Appeal Decision

Appeal Ref: APP/C3810/A/12/2187003

115 - 117 Sea Road, East Preston, Littlehampton, BN16 1NX

- The appeal is made under section 78 of the Town and Country Planning Act 1990 against a refusal to grant planning permission.
 - The appeal is made by Oakhurst Developments Ltd against the decision of Arun District Council.
 - The application Ref EP/40/12/, was refused by notice dated 17 October 2012.
 - The development proposed is 9 flats with associated parking and amenity space following demolition of existing buildings.
-

number: 3279/P100
rev: C
dwn: twn
chkd: ge
appd: ge

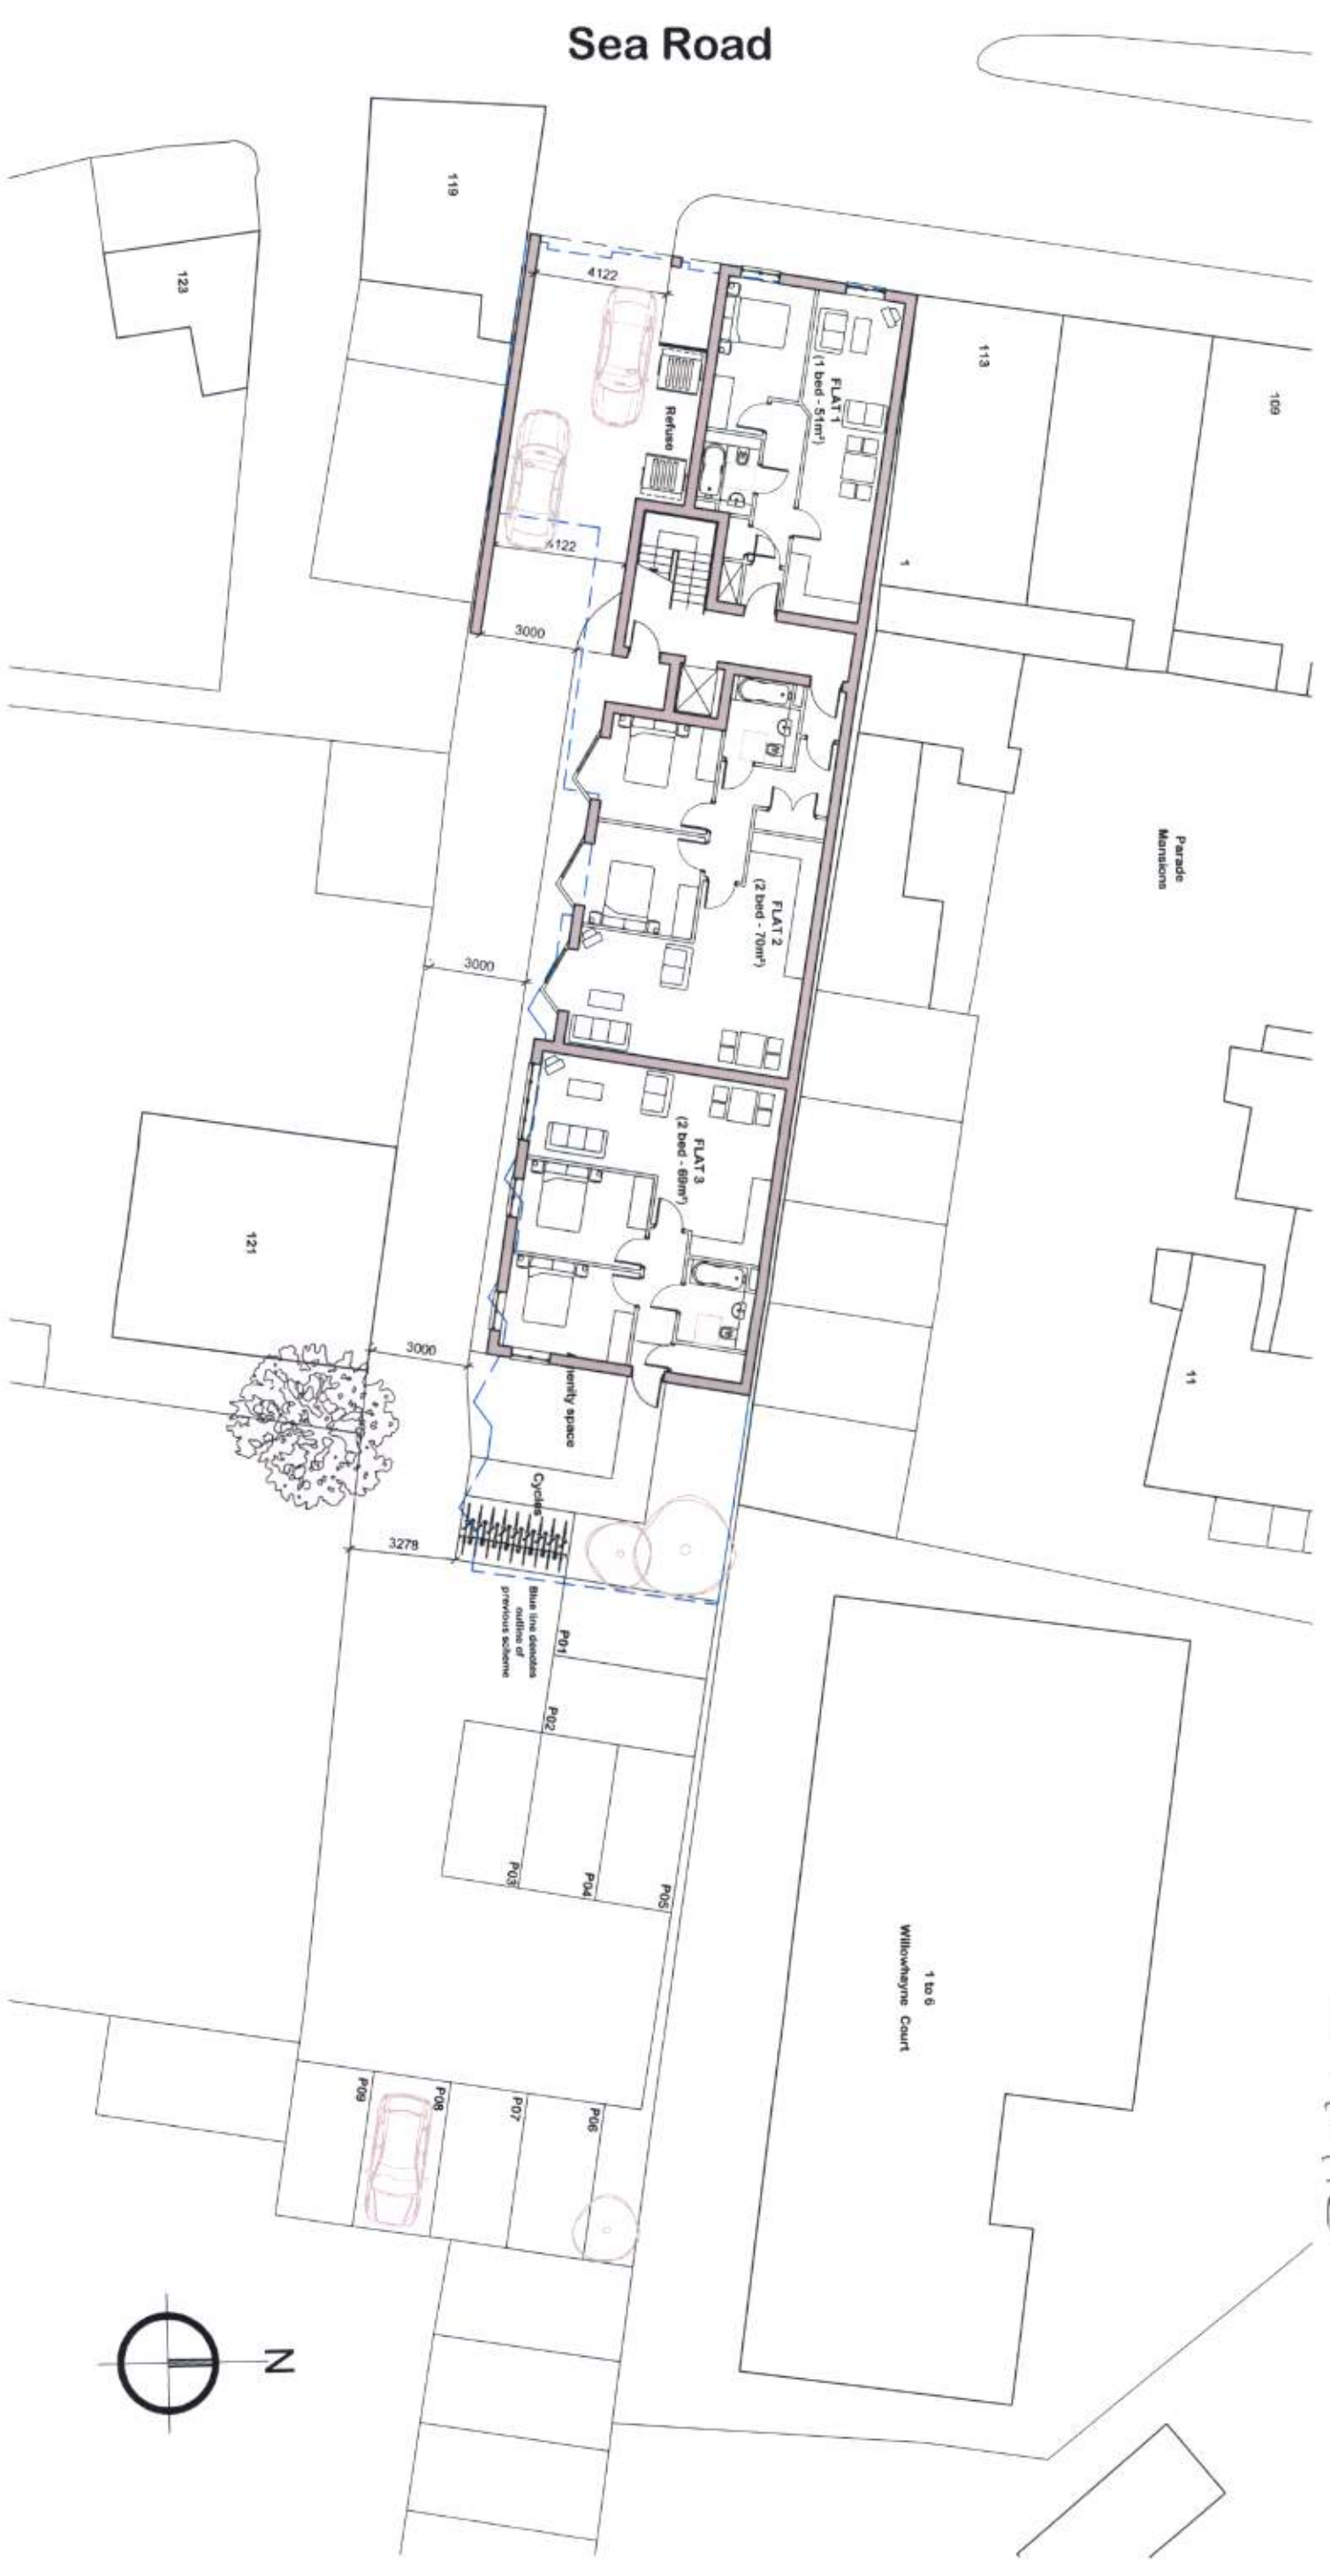
10. The proposed flats on the first floor of the central two-storey flat roofed linking section are located so as to have potential to look over the area to the front of No 121 Sea Road, which includes a garage, parking area and courtyard garden, and the rear of Coastguard Cottages beyond. The main garden area of No 121 lies to the east of the dwelling, and would not be affected by views from these windows. I note that this section of the proposed development would have canted windows, with obscure glazing facing towards the west elevation of No 121, so there would be no direct overlooking of windows in the elevation. Nevertheless the need for this arrangement emphasises the very close relationship between the existing dwelling and the proposed new flats. Notwithstanding the obscure glazing I consider that the proximity of these windows would give rise to a perception of loss of privacy which occupiers of No 121 would find intrusive.

11. The effect of this central element on Coastguard Cottages would be less harmful, due to the greater separation distance between the proposed flats and the rear windows of Coastguard Cottages. The privacy of these windows and the gardens would be protected by intervening walls and some screening vegetation, which I saw to be reasonably effective even in winter. However the first and second floor flats in the front section would have bedroom windows facing over 125 Sea Road and this end of Coastguard Cottages. These windows would be significantly closer than the habitable room windows in the existing building on the site to be demolished. They would allow an unacceptable degree of overlooking which would be harmful to the living conditions of neighbours.

number: 3279/P201 rev: D  
dm: agw chkd: ge appd: ge

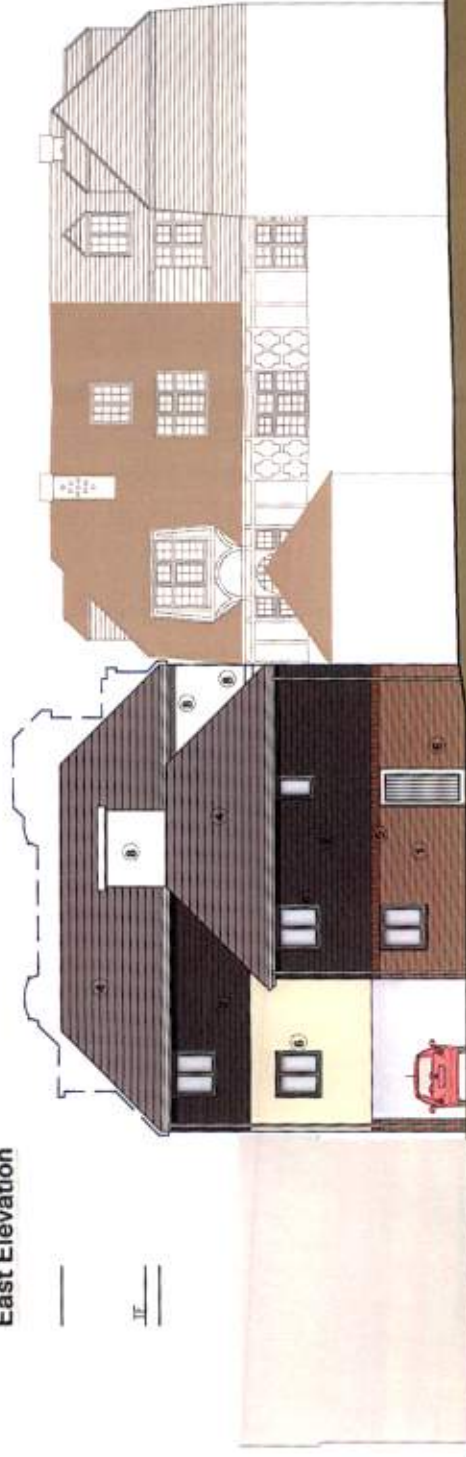
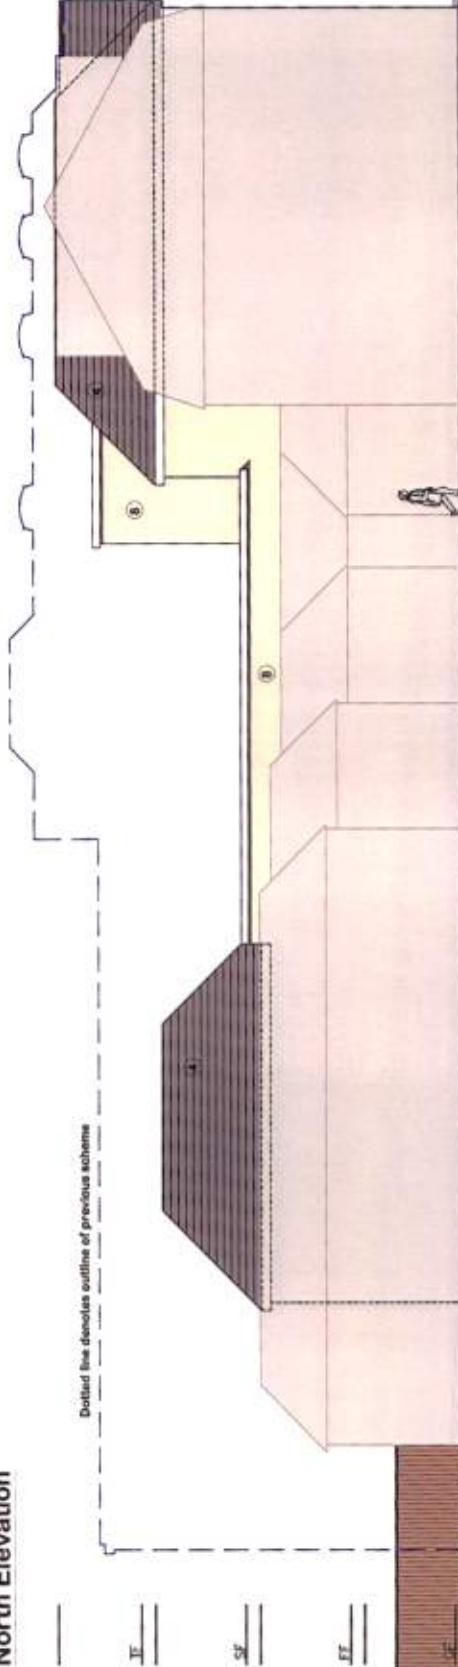
6. The design of the appeal scheme fails to pay sufficient regard to its context. While the roof line has been lowered following refusal of a previous proposal, the crown roof of the frontage block would be almost the same height as Parade Mansions. The elevation facing Sea Road would compete in scale with Parade Mansions, but exhibits little in the way of distinctive design detail that would respond in a positive way to the characteristics of its neighbour. The ground floor treatment, with small domestic scale windows facing the street alongside the vehicle access, offers a bland and uninteresting appearance which represents a loss of visual interest in contrast with the shop front it would replace. The asymmetric gable facing Sea Road and the small gablet above the site entrance are weak features which contrast adversely with the strong detailing of Parade Mansions. Notwithstanding the use of contrasting materials, the south elevation of the main frontage block would present a somewhat featureless wall which would be prominent in views from the south and in the outlook from the rear of Coastguard Cottages.
